Our Ref: EN010132

Date: 2 May 2024

The Infrastructure Planning (Examination Procedure) Rules 2010 (as amended) – Rule 17

Application by West Burton Solar Project Limited for an Order Granting Development Consent for the West Burton Solar Project

Figure 1. Location of heritage assets associated with Stow Park Deer Park, Stow Deserted Medieval Village and a possible early medieval settlement in the west of West Burton 3.

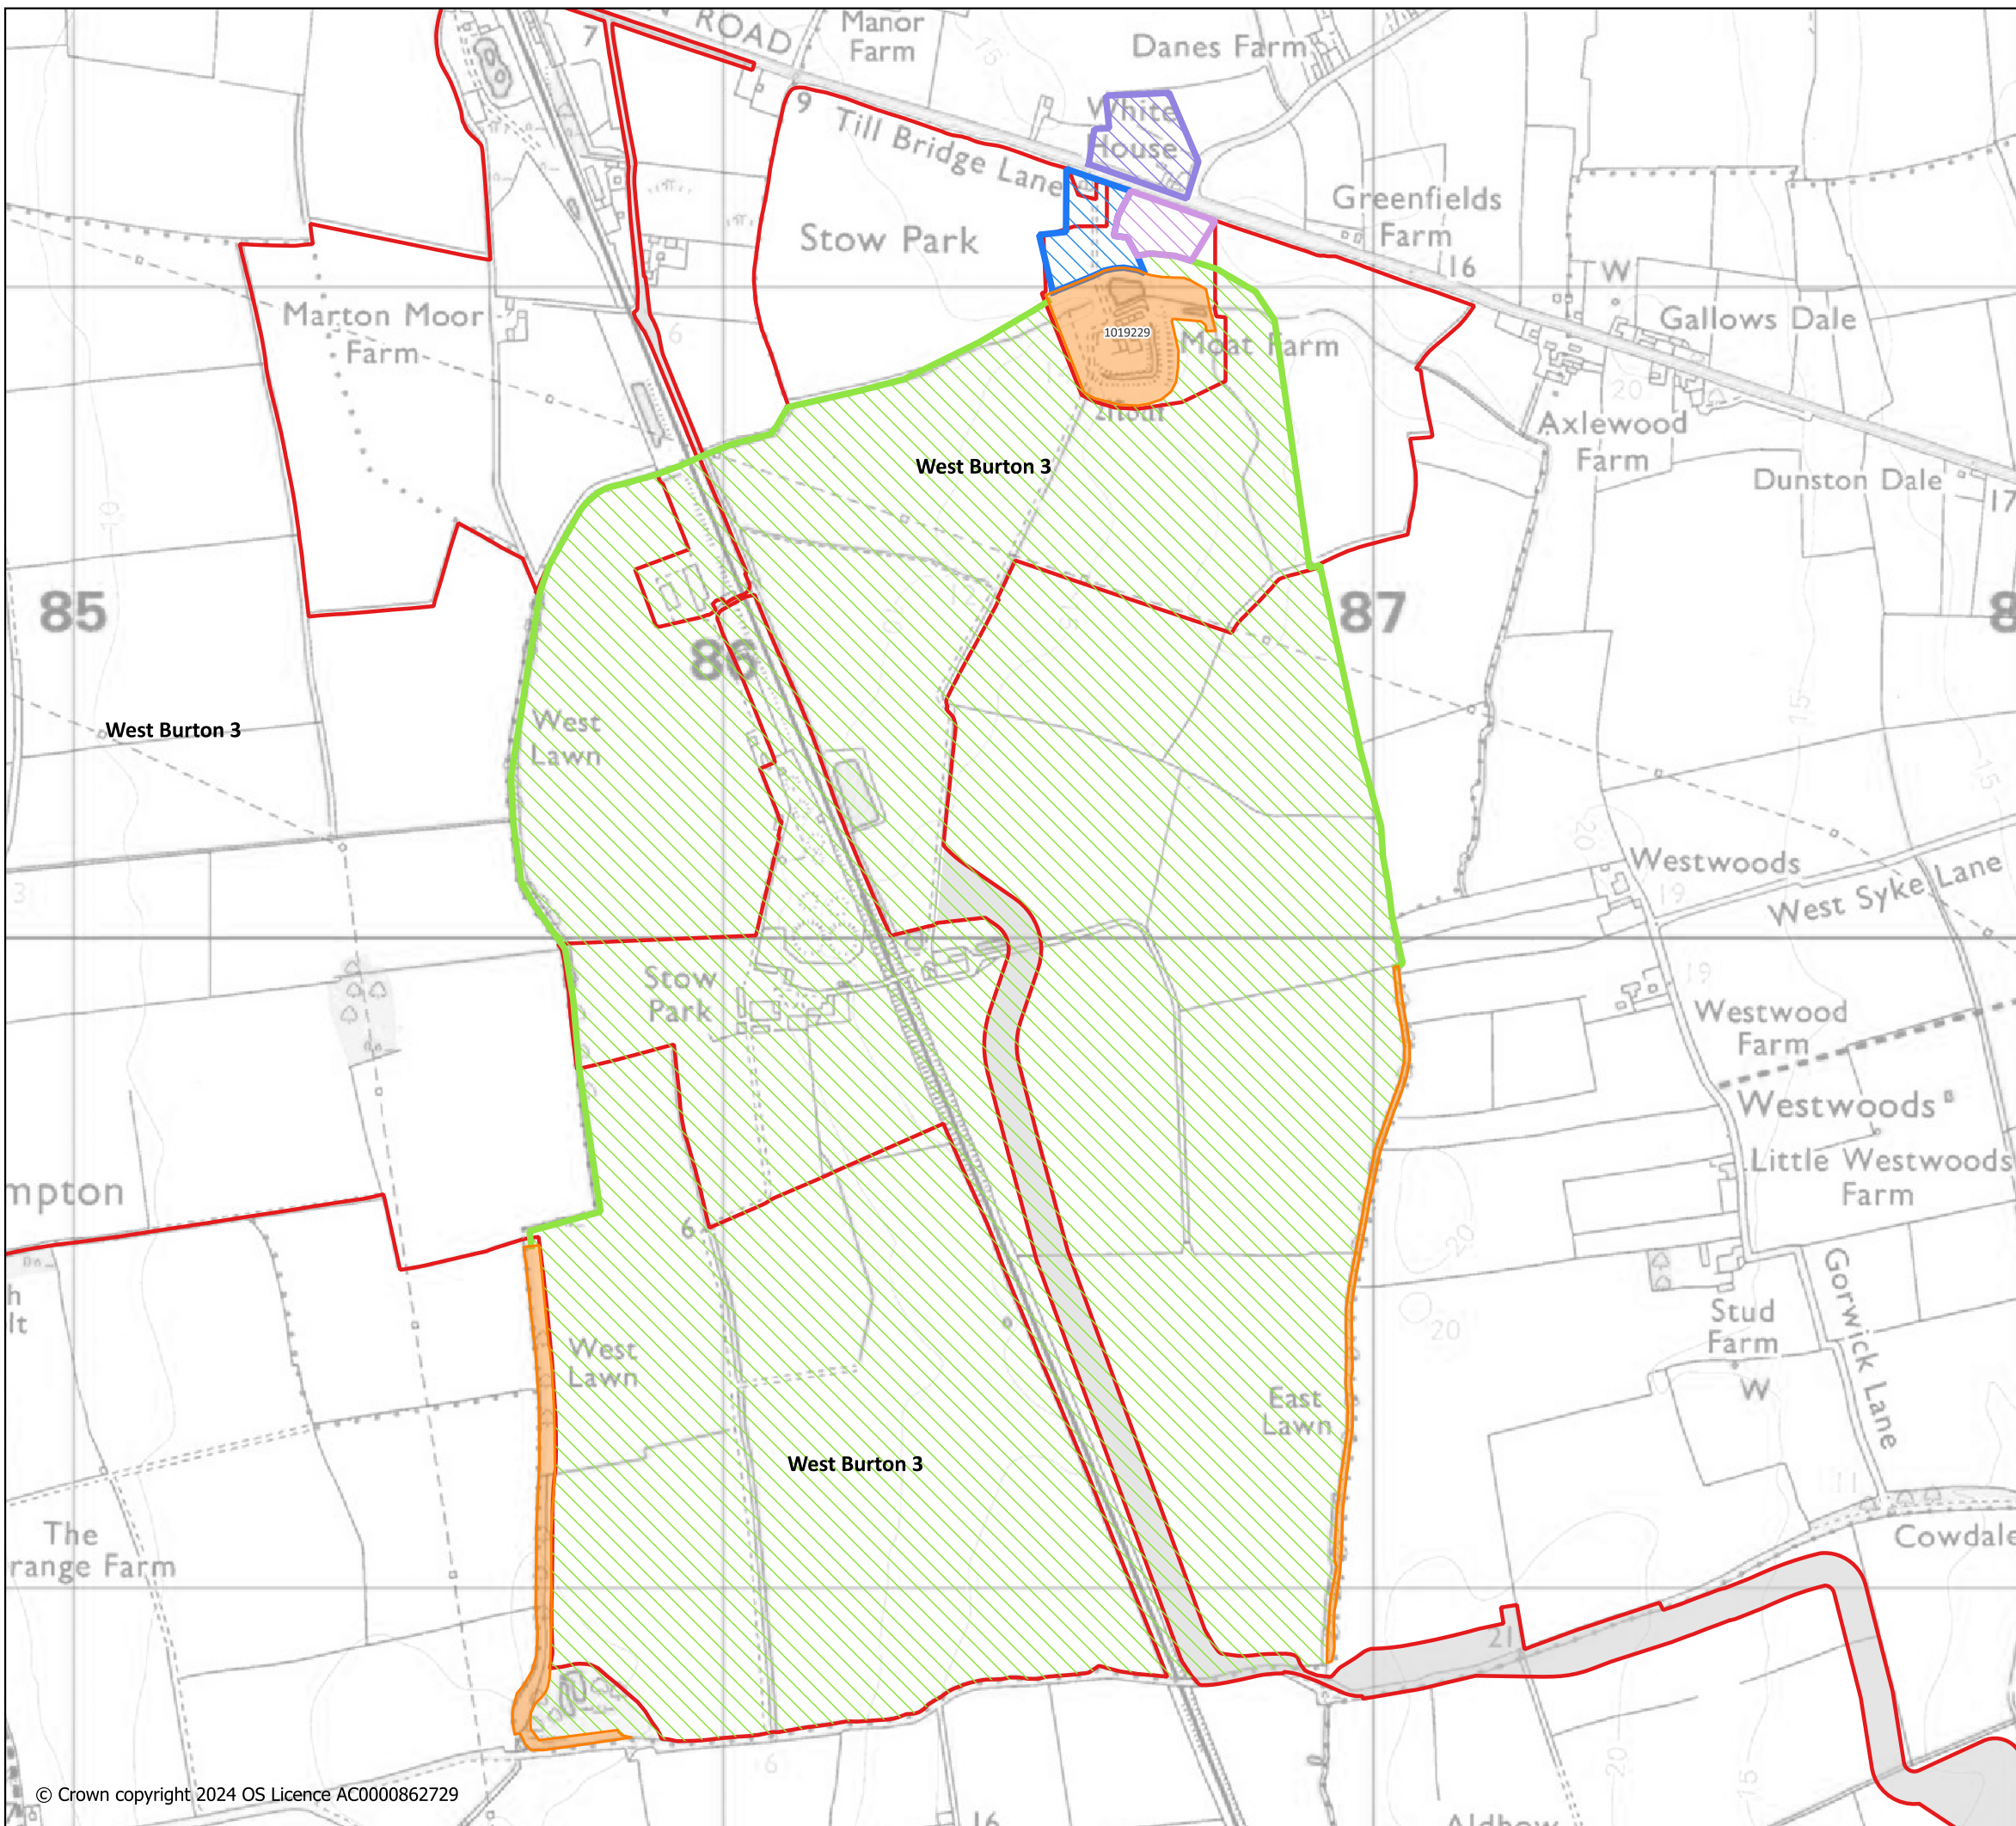
Question 7 of the Rule 17 letter dated 23 April 2024 refers to the area within the Order Limits representing the former Stow Park Deer Park (as shown in Figure 1 of the Stow Park Cultural Heritage Position Statement [\[REP5-027\]](#)). It seeks clarification on how the installed capacity within this area would relate to the overall electricity generating capacity of the Proposed Development. In their [response provided at Deadline 6](#) the Applicant sets out that this area would be responsible for approximately 20% of total generating capacity.

Should the Secretary of State conclude that the harm to the Scheduled Ancient Monument outweighed the need for the Proposed Development, the Applicant is asked to consider whether an amendment to exclude panels from the area shown in Figure 1 would represent the same Nationally Significant Infrastructure Project as originally applied for.

If it would, then the Applicant is asked to consider, on a without prejudice basis, the alterations that would be required to the Order Limits, the Development Consent Order, the Land Plan, the Works Plan, and any other necessary alterations, to accommodate the changes that would be required to the application.
